Application No: AW/81/21/HH
Site Address: 2 Old Farm Close Aldwick PO21 4AX
Description of works: Two storey extension.

Thank you for your internet representation made on 29th March 2021 which has been recorded as an objection with the comments as follows:

Proposed second floor plan 1:100

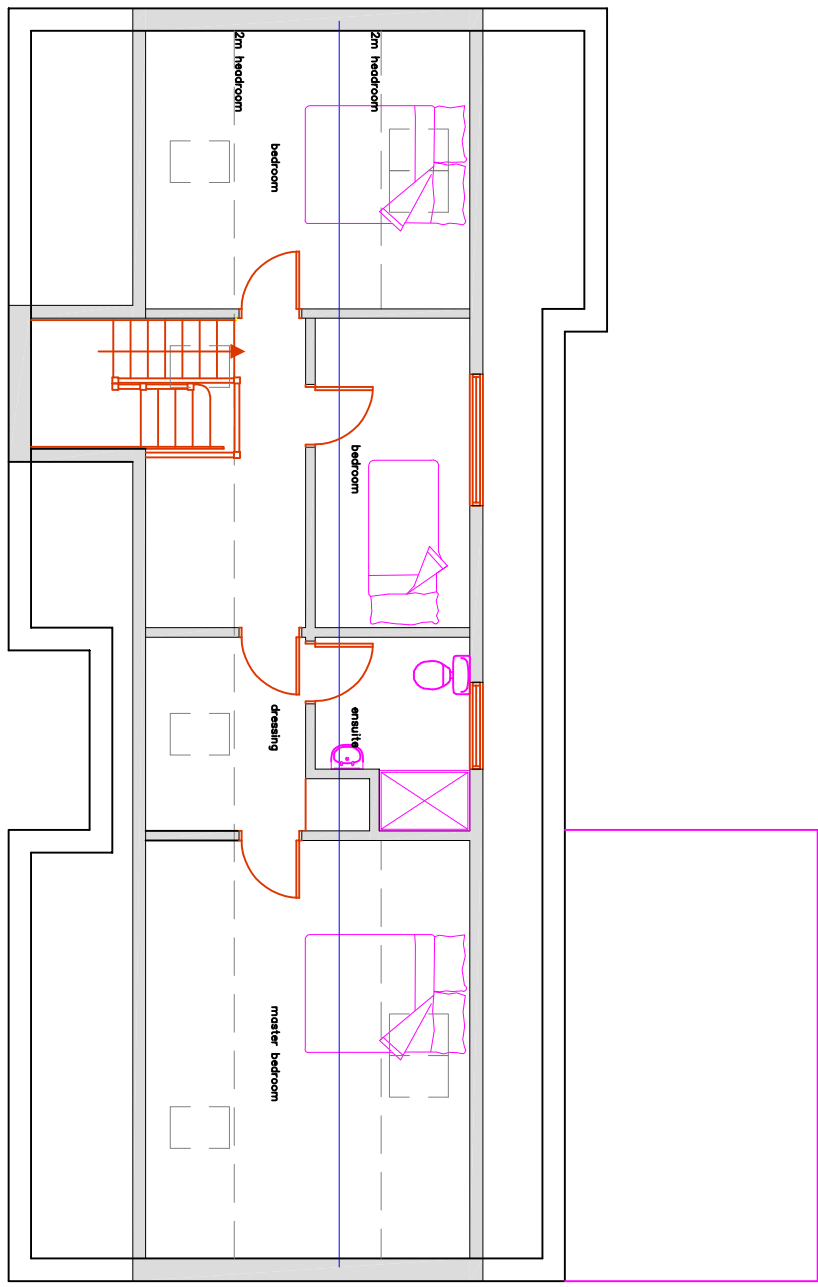
The third storey extension across the full width proposes 9 new windows to the rear inc. a dormer section all of which would directly overlook our property, it infringes our right to privacy, this is the significant objection. 4 windows are proposed for the front.

The 2 storey side extension is stated for a dependent relative but is not accessible from the second storey and is a self contained unit with a kitchen and 2 bathrooms. Access on the ground floor is limited to one door by the front door. It is not accessible from the 3rd storey. Impractical for caring, also a second kitchen for a dependent relative is not logical, surely the family will be caring for the relative as stated.

Proposed south west elevation 1:100

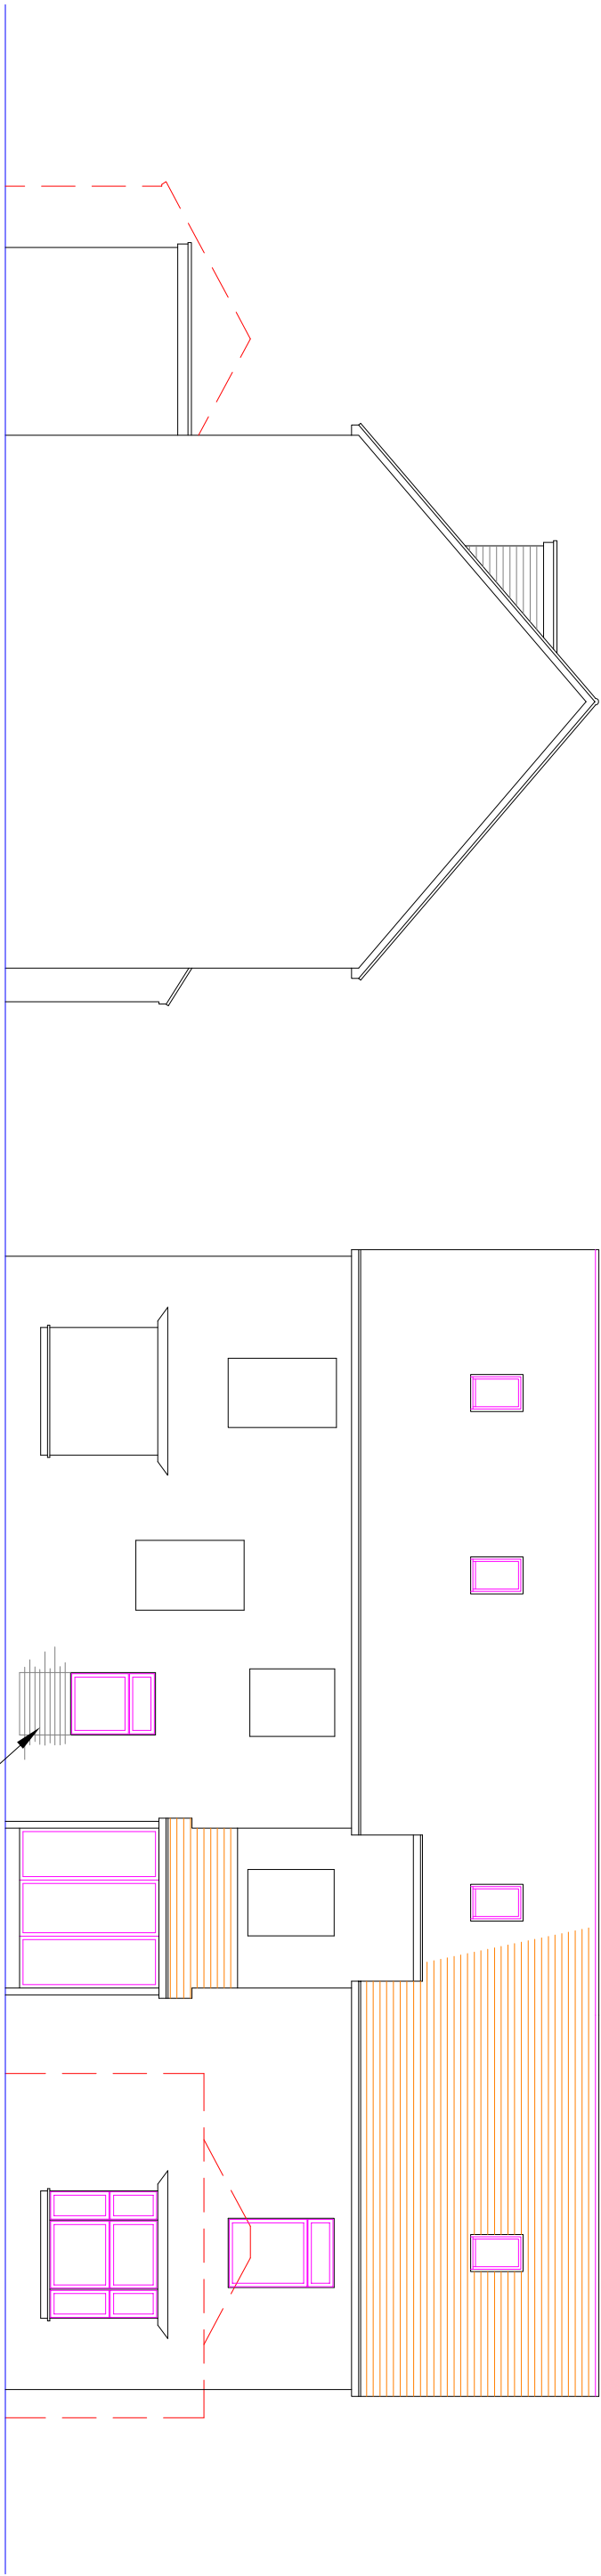
The balcony on the second storey would overlook ours and other properties with associated loss of privacy, also significant for us and others.
